Application No: EP/16/21/PL
Site Address: Land East of 1 The Way East Preston BN16 1QJ
Description of works: Replacement garage. This site is in CIL Zone 4 (Zero Rated) as other development.

Thank you for your internet representation made on 24th May 2021 which has been recorded as an objection with the comments as follows:

I am commenting on behalf of the East Preston and Kingston Preservation Society.

Drawing Number: 1241.01.h

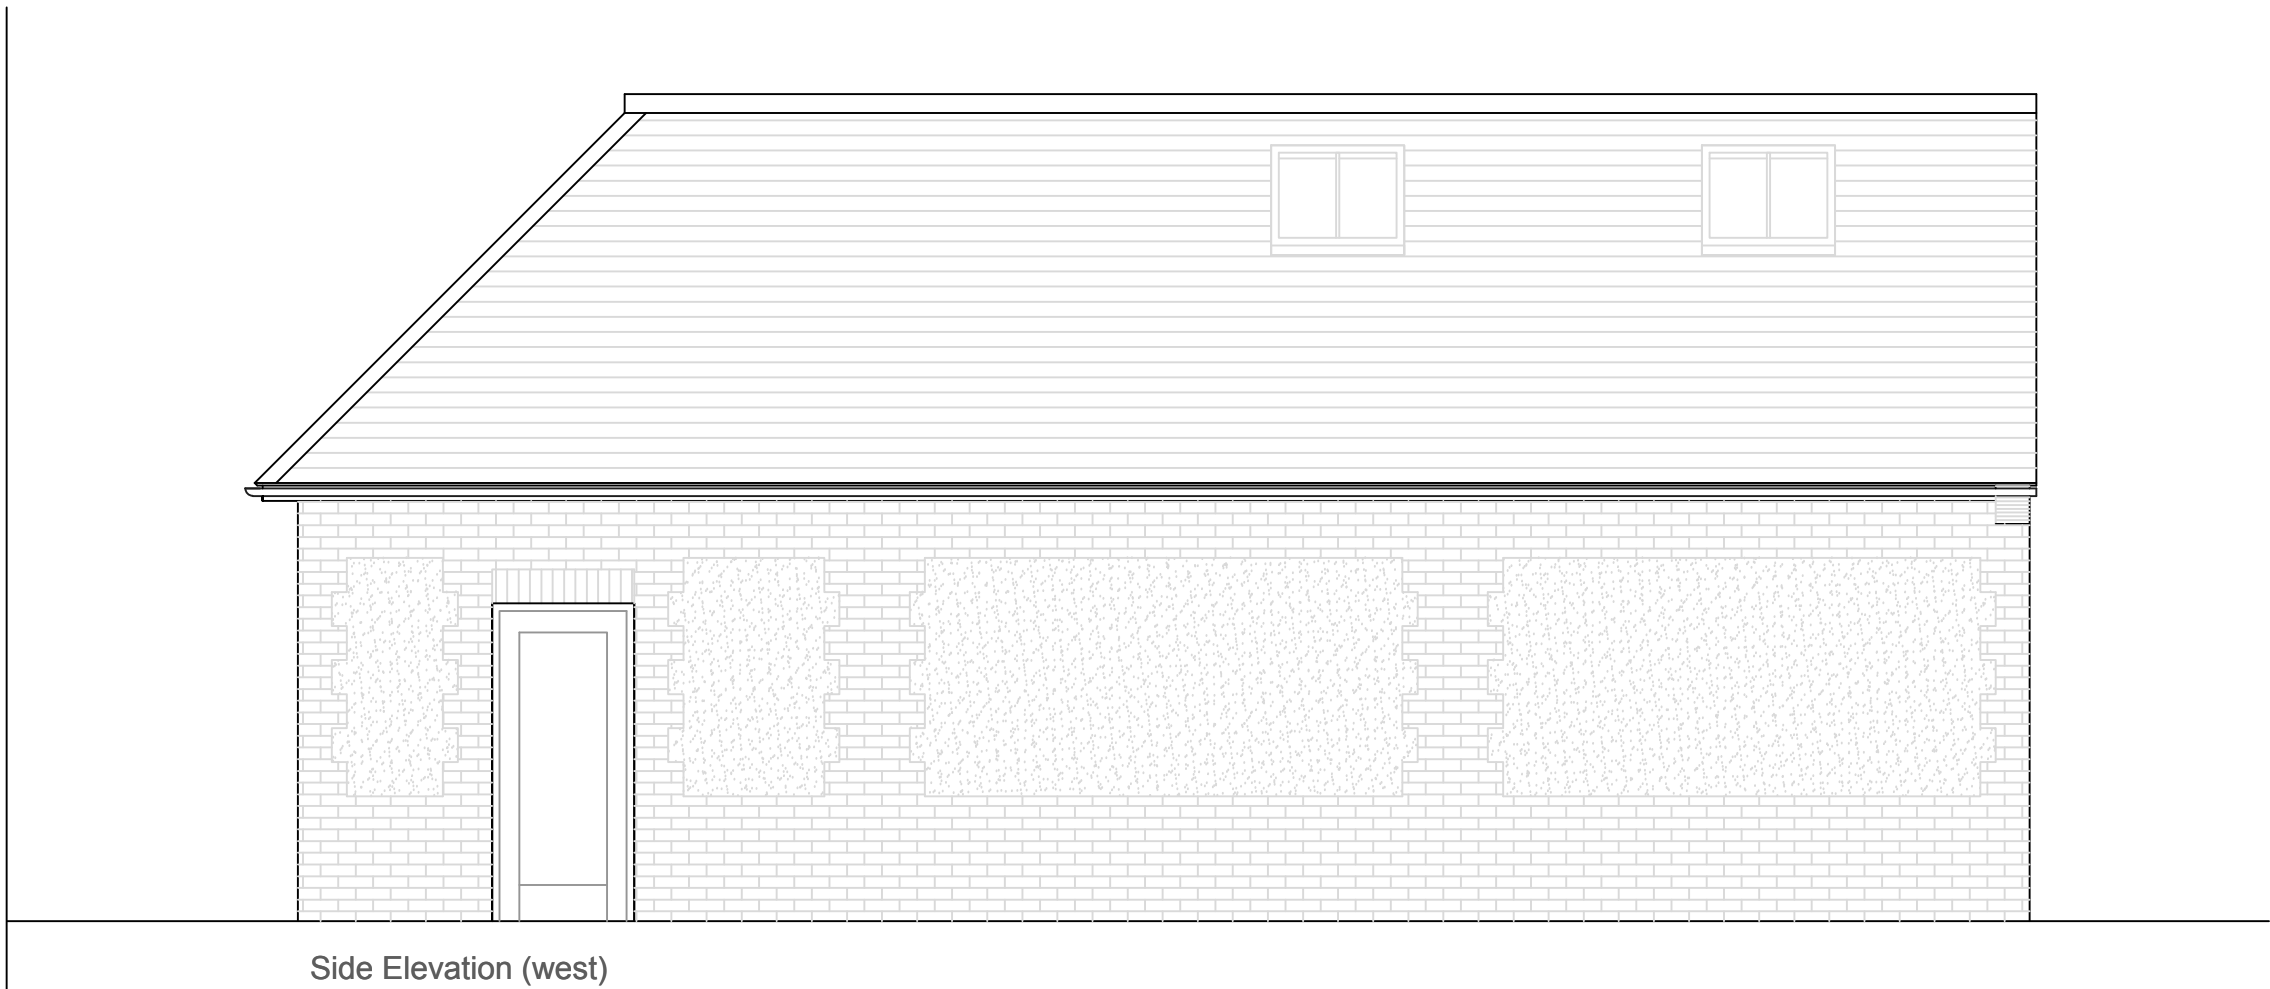
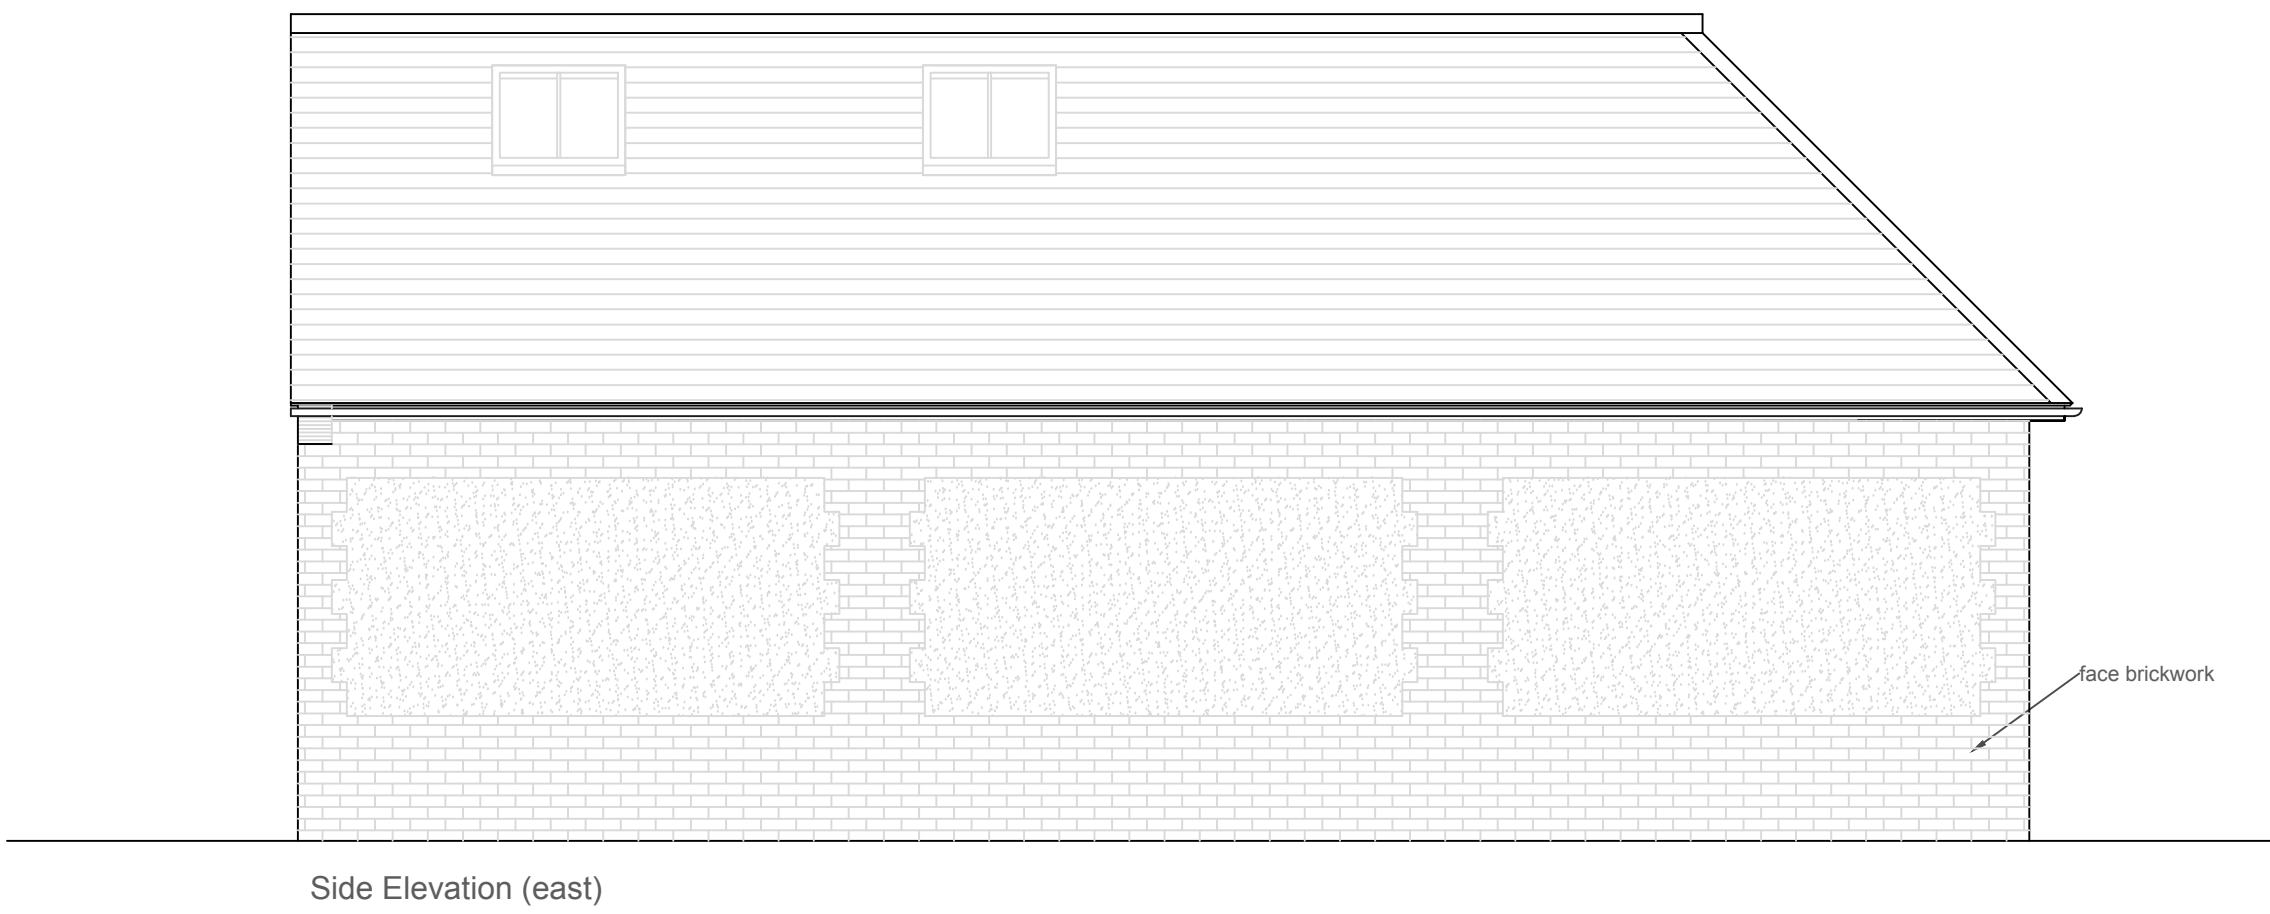
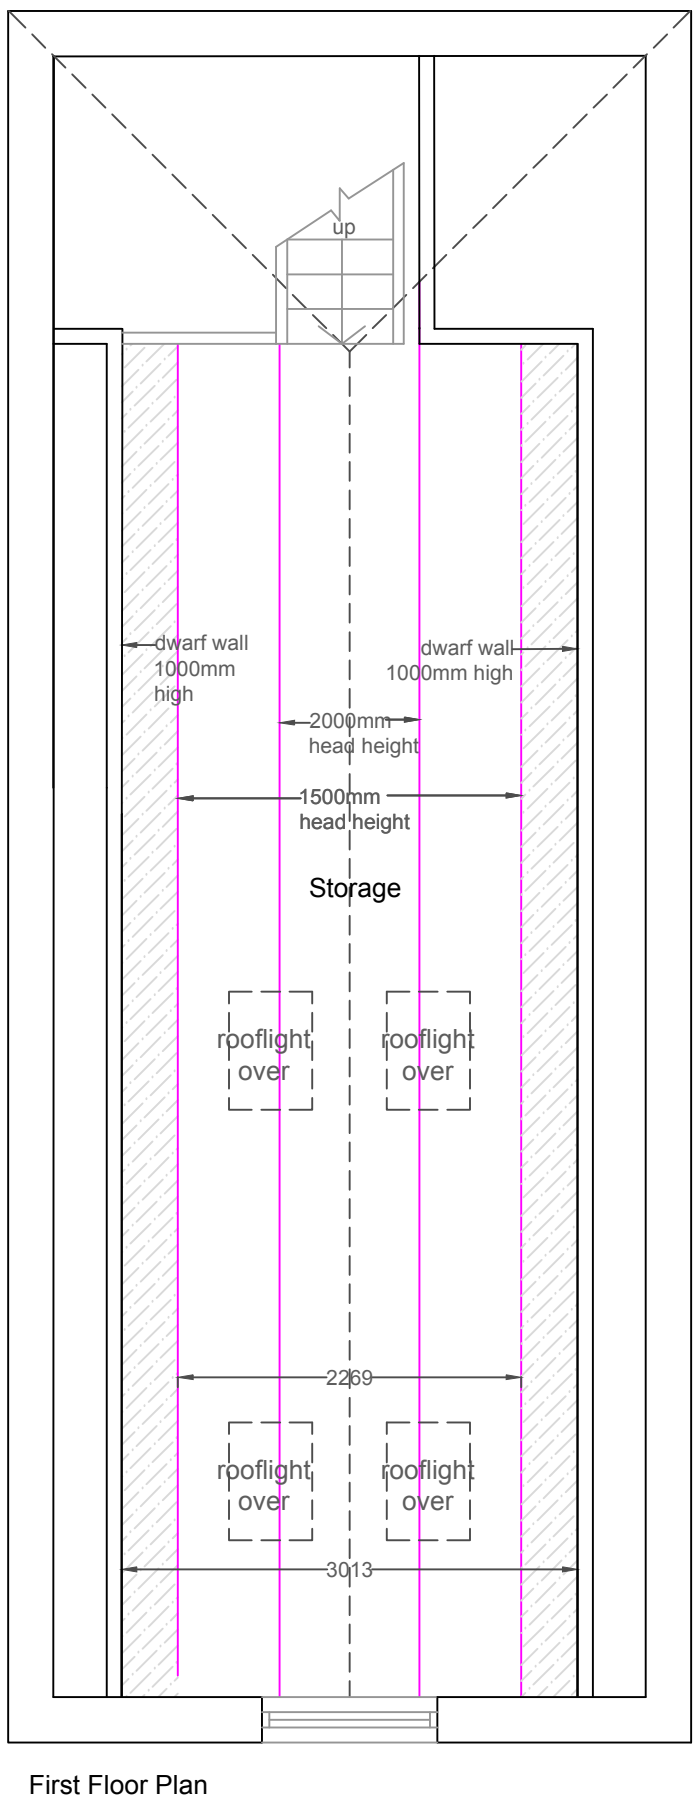
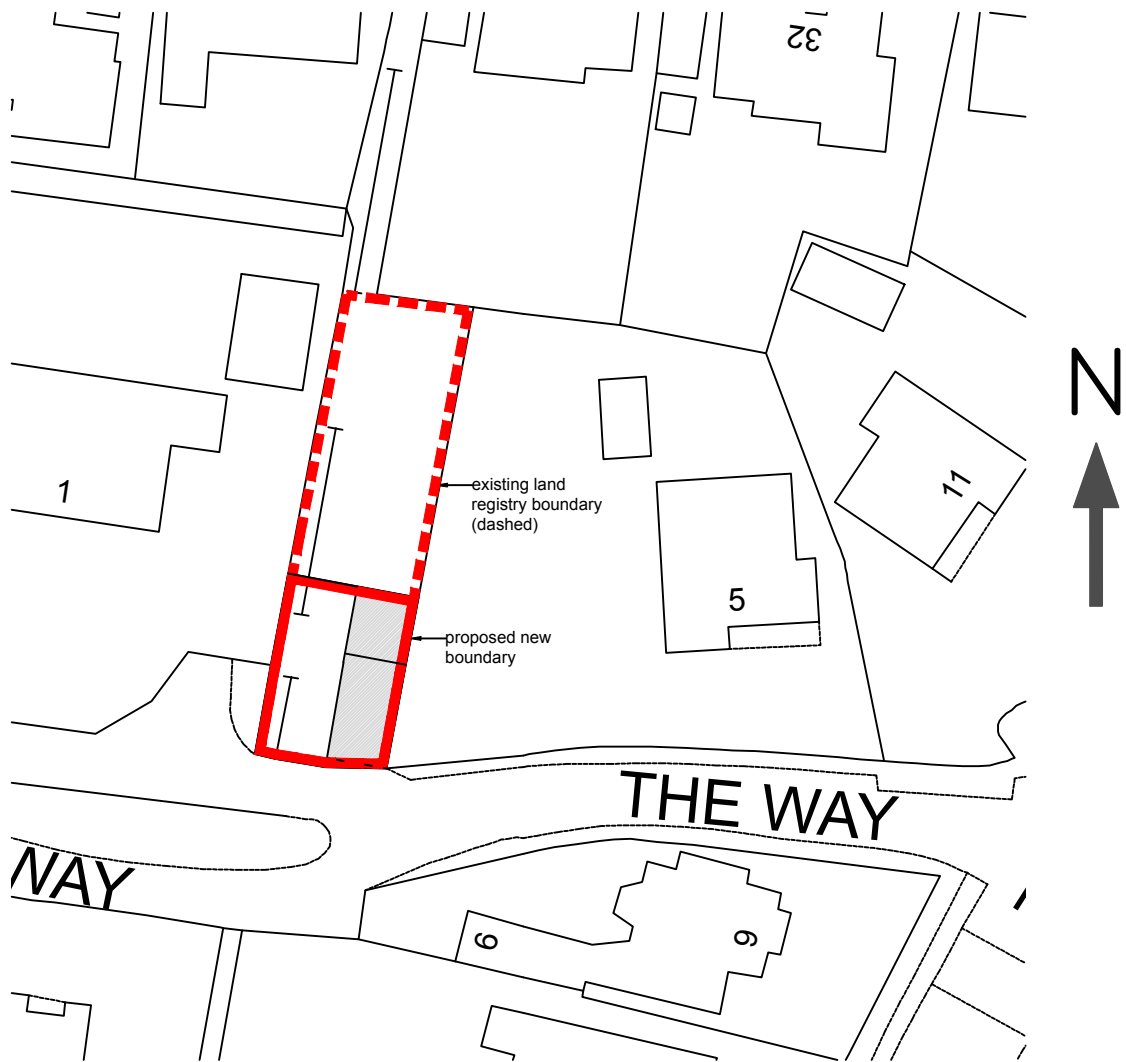
The minor changes to the design of the proposed building do not address the features of the original proposal which the Society found objectionable. The building is still sited so that its gable end, which is about 5.5 metres high, is 1.2 metres from the edge of the tarmac road surface. The old garage was about 2.5 metres high, and in the same position. As the road is about 4 metres wide, the gable would be taller than the road is wide, transforming the street scene. The new building would sit far in front of the neighbouring houses; 5 The Way is set 6 metres back from the road and 1 The Way is set 13 metres from the road.

This proposal therefore contravenes Policy D DM1 because the new building would not reflect the character of the area, especially in relation to its siting; and it contravenes Policy 2 of the East Preston Neighbourhood Plan, because it would harm the street scene. Although it is not a planning consideration, I would add that a garage entrance opening directly onto a narrow road produces practical problems in getting a car in and out of the garage. A garage set back from the road would be more practical.
